Recommendation Report for Planning Permission

REF NO: BN/97/21/PL

LOCATION: Land to rear of Birchwood House
Church Lane
Barnham
PO22 0DB

PROPOSAL: Retention of existing site entrance (resubmission following BN/110/20/PL). This site is in CIL Zone 3 (Zero Rated) as other development.

Drawing Details	
Photographs of site access	
Planning Issue	
Drawing No. C0117-P014	Date September 2020
Scale -	Revision -

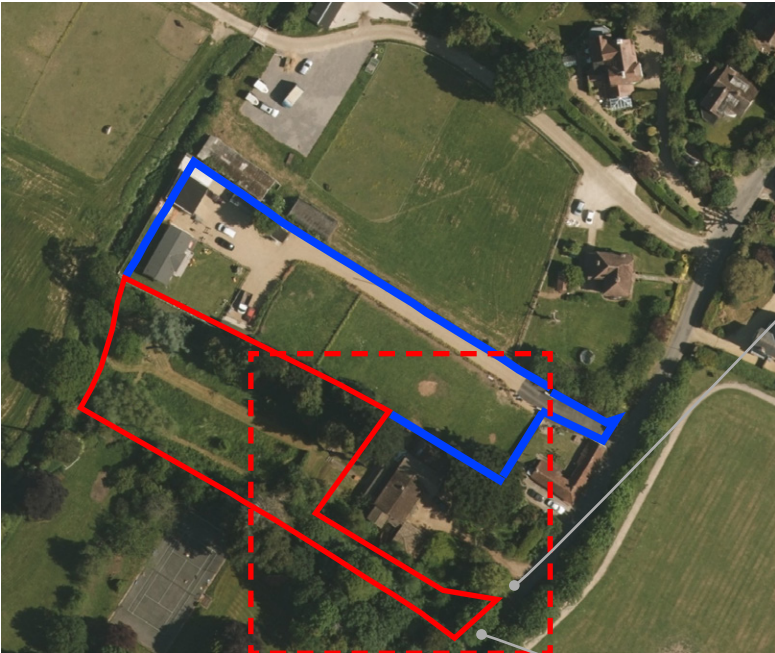
Based on the photos provided, the new boundary treatment, gates and gravel, by reason of their scale, materials and finish, would be sensitive to their location, reflective of their rural context, and have an acceptable impact on the street scene along this part of Church Lane. The proposals would therefore appear to accord with policies D SP1 and D DM1 of the ALP, policies ES5 and ES6 of the B&ENP 1, and the principles within the B&E Design Guide (2020) and the ADC Design SPD (2021). Full plans and elevation drawings would be required to tie into the approved plans condition of a Decision Notice in the event of planning permission being granted.

Recent historic imagery indicates that prior to the new access being created this area of the site was overgrown and consisted of trees and scrub/hedgerow. The application states that no trees have been removed as a result of the development. The photos supplied may suggest otherwise, with a large tree stump clearly visible in the foreground just behind the new fencing. However, it is unclear if this tree work

was historic, and even if it has been removed as a result of this development nothing can now be done as the damage has already occurred and this tree cannot be protected/managed, which is obviously regrettable if that is the case. Notwithstanding this, all other trees appear to be retained. Furthermore, the Council's Tree Officer has been consulted on this current and the withdrawn application and provided no comments/objection. Under the related enforcement case, they have confirmed they have no issues with the application in respect of tree impacts.

Drawing Details	
Site Location Plan Planning Issue	
Drawing No. C0117-P012	Date September 2020
Scale ISSUED 1:1250 @ A3	Revision A

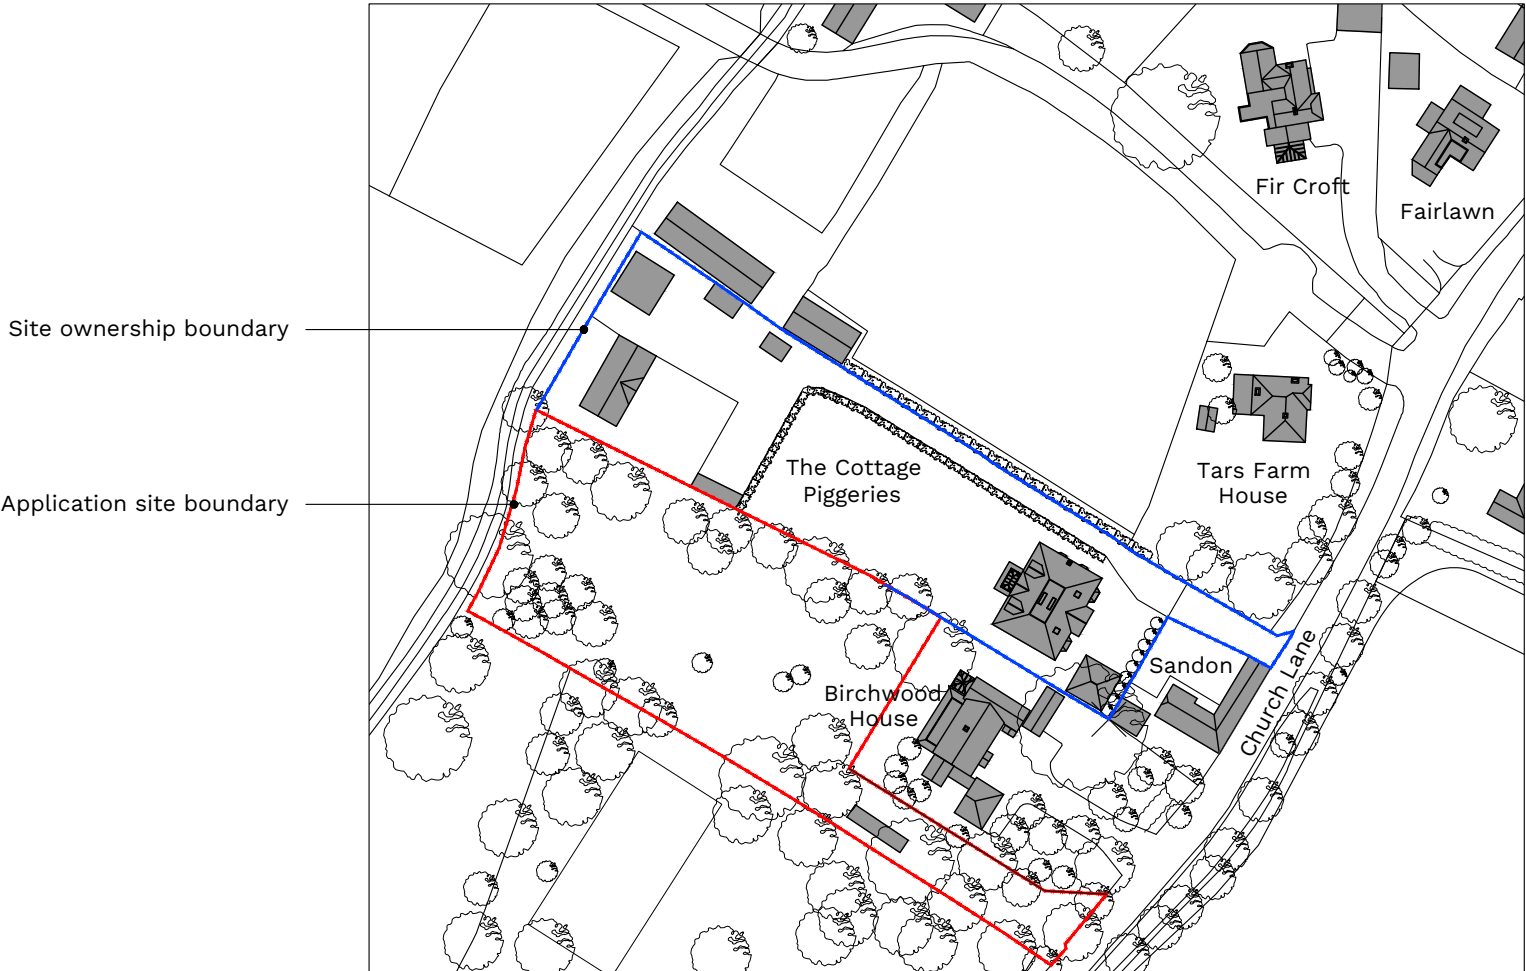
In addition, it is considered that the matter of land ownership of all land within the red line site boundary and development area has still not been satisfactorily addressed. The previous application (BN/110/20/PL) was withdrawn in part on the basis that the red line site boundary shown on the Site Location Plan did not encompass the whole development area where the new access is sited and evidence had not been provided that the applicant owned all of the land on which development was located and thus whether notices had been served on the correct person/s or not and if the application form Certificate was accurate or not. Under this current application, the red line site boundary on the Site Location Plan now includes the whole development area and a document entitled 'Proof of ownership' has been submitted which seems to show a plan of the land and some form of land title. However, the image is not at all clear or readable and so the details of this cannot be confirmed and the matter of land ownership remains inconclusive. In the event of a future planning application or planning appeal, clear details of land ownership must be provided, and if the red line site boundary includes land not owned by the applicant then notices need to be served on those others with an interest in the land and the correct Certificate completed and a revised application form supplied.
